**The Yews, Main Street, Sibford Gower, Banbury,  
OX15 5RT**

**20/00641/F**

**Proposal:** Raise roof height of bedroom and conservatory; install 10 No solar panels; replace all UPVC windows and doors with timber framed alternatives

Proposed Alterations to existing Rear Single Storey Extension on the Yews, Main Street, Sibford Green, OX15 5RT for Mr & Main.

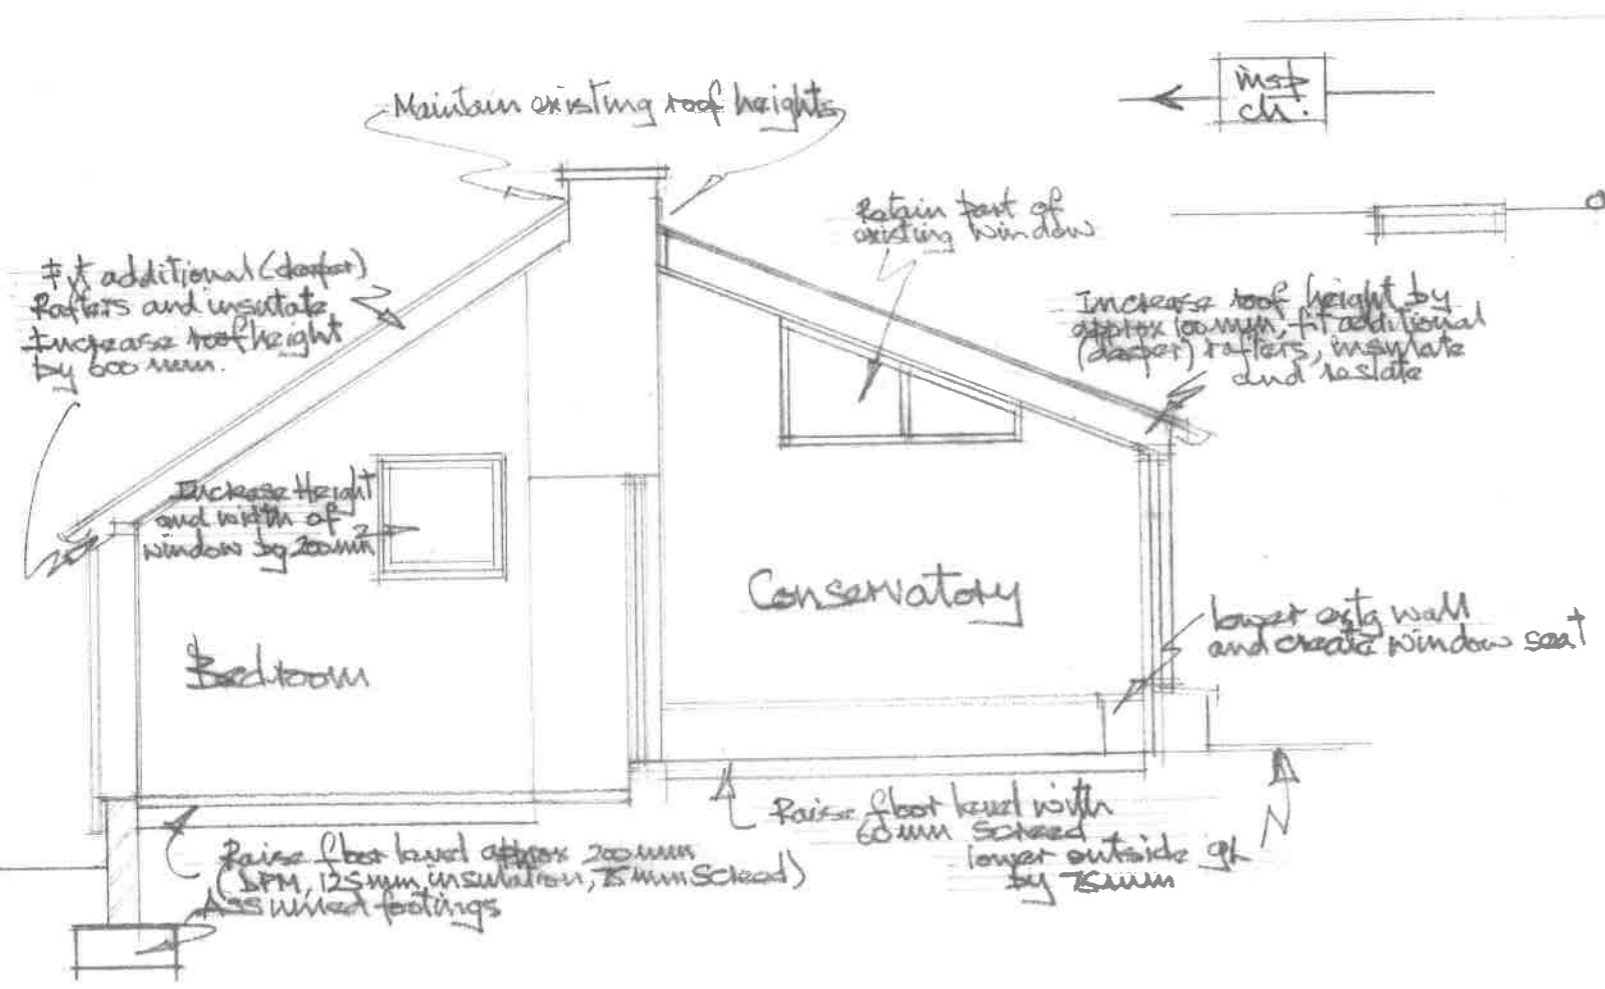
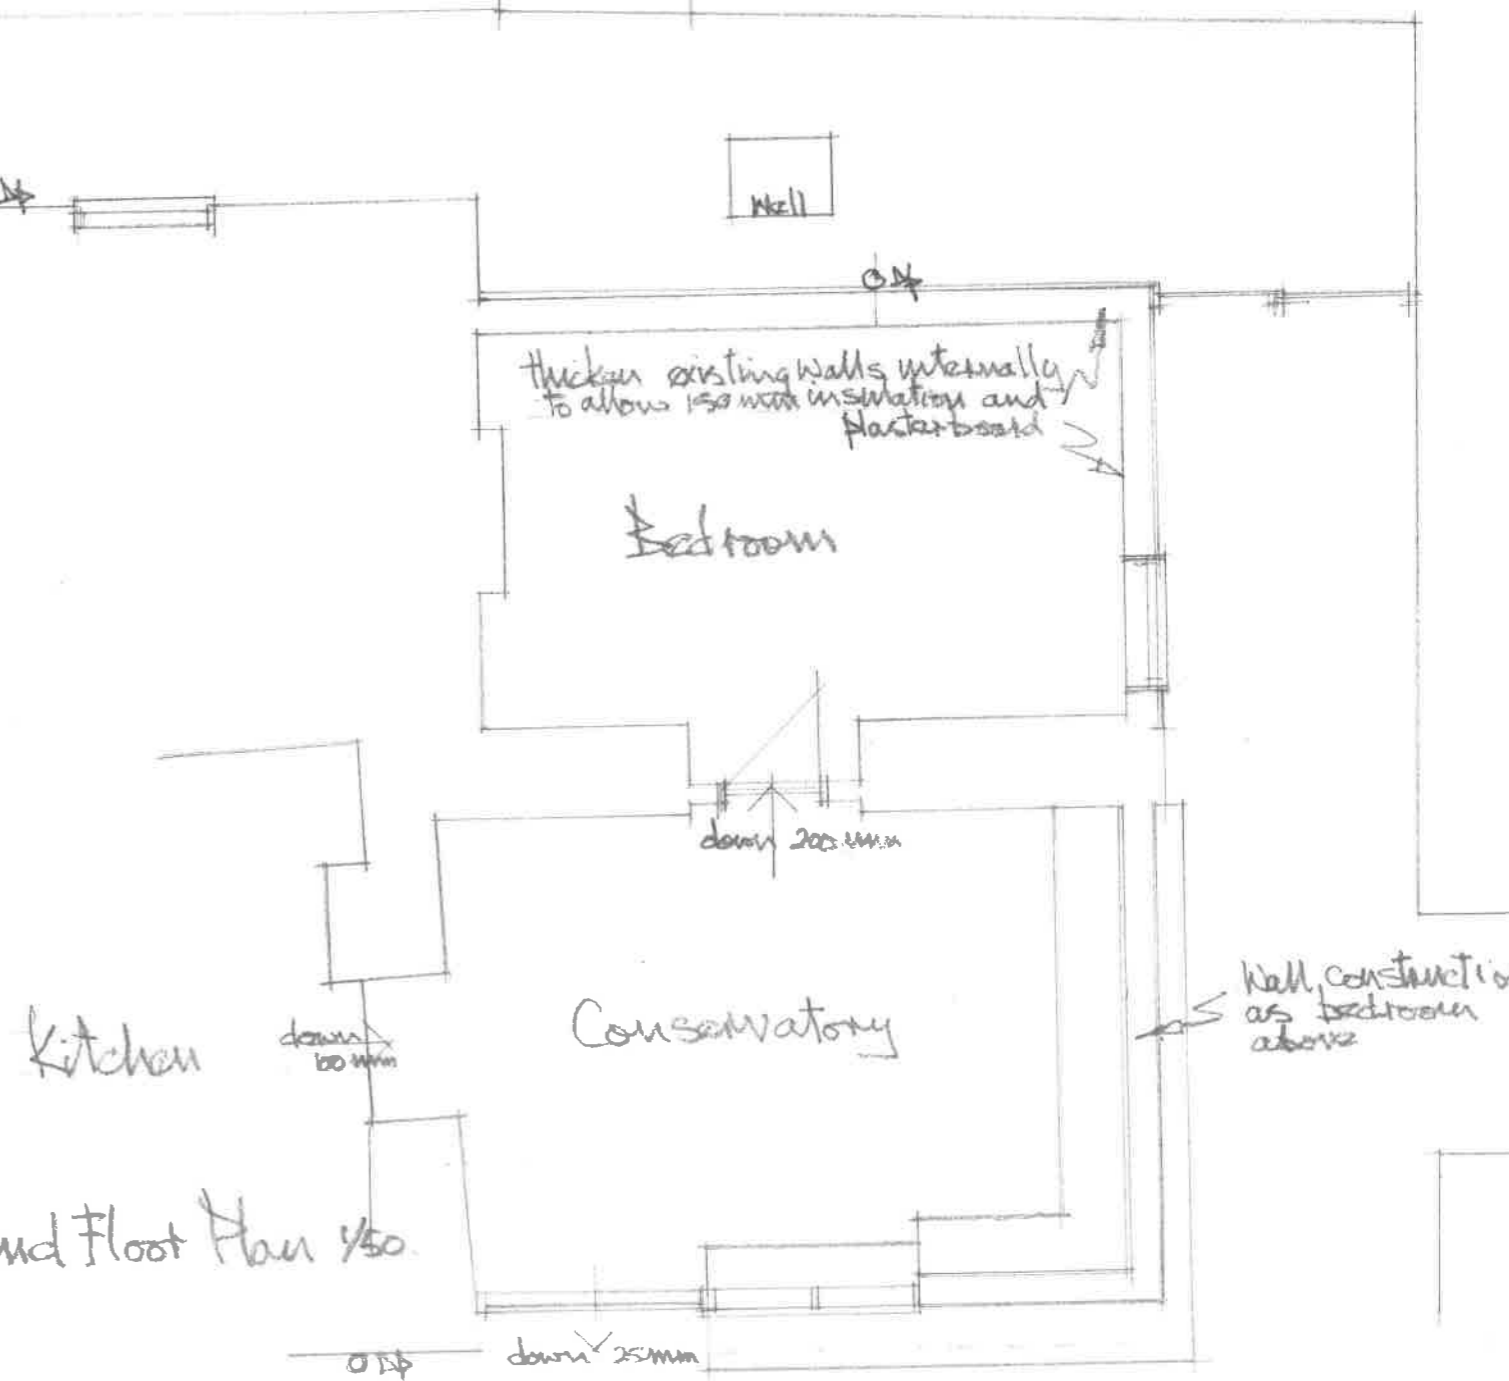
- 8.7. The increase in roof height upon the rear projection would represent a minor alteration and an enhancement over the existing corrugated sheeting, that would not detract from the visual amenities of the area, or the historic significance of heritage assets or their setting. The use of timber cladding upon dwellings is generally discouraged throughout the District, although given that the works would involve the replacement of existing timber cladding, and the installation of further timber cladding where it already exists, I do not consider that I could reasonably resist its use. The proposal therefore accords with the above Policies in terms of visual impact.

- 8.9. The work would involve the replacement of existing openings, rather than the creation of new ones, and I do not consider that a significant additional loss of privacy would occur. The bedroom would be slightly larger and of a higher positioning, although it would remain at ground floor level and I consider that views towards the neighbours, including swimming pool are unlikely to differ significantly from those existing. The conservatory already has high level openings in the south facing elevation.

- 8.10. The increase in roof height would take place directly opposite a ground and first floor opening at 2 The Cross with limited separating distance. However, I do not consider

that the increase in height, or replacement of timber cladding, would result in a significant additional loss of amenity in terms of overshadowing, loss of outlook or overbearing appearance from that existing. No openings are proposed to face towards this neighbour.
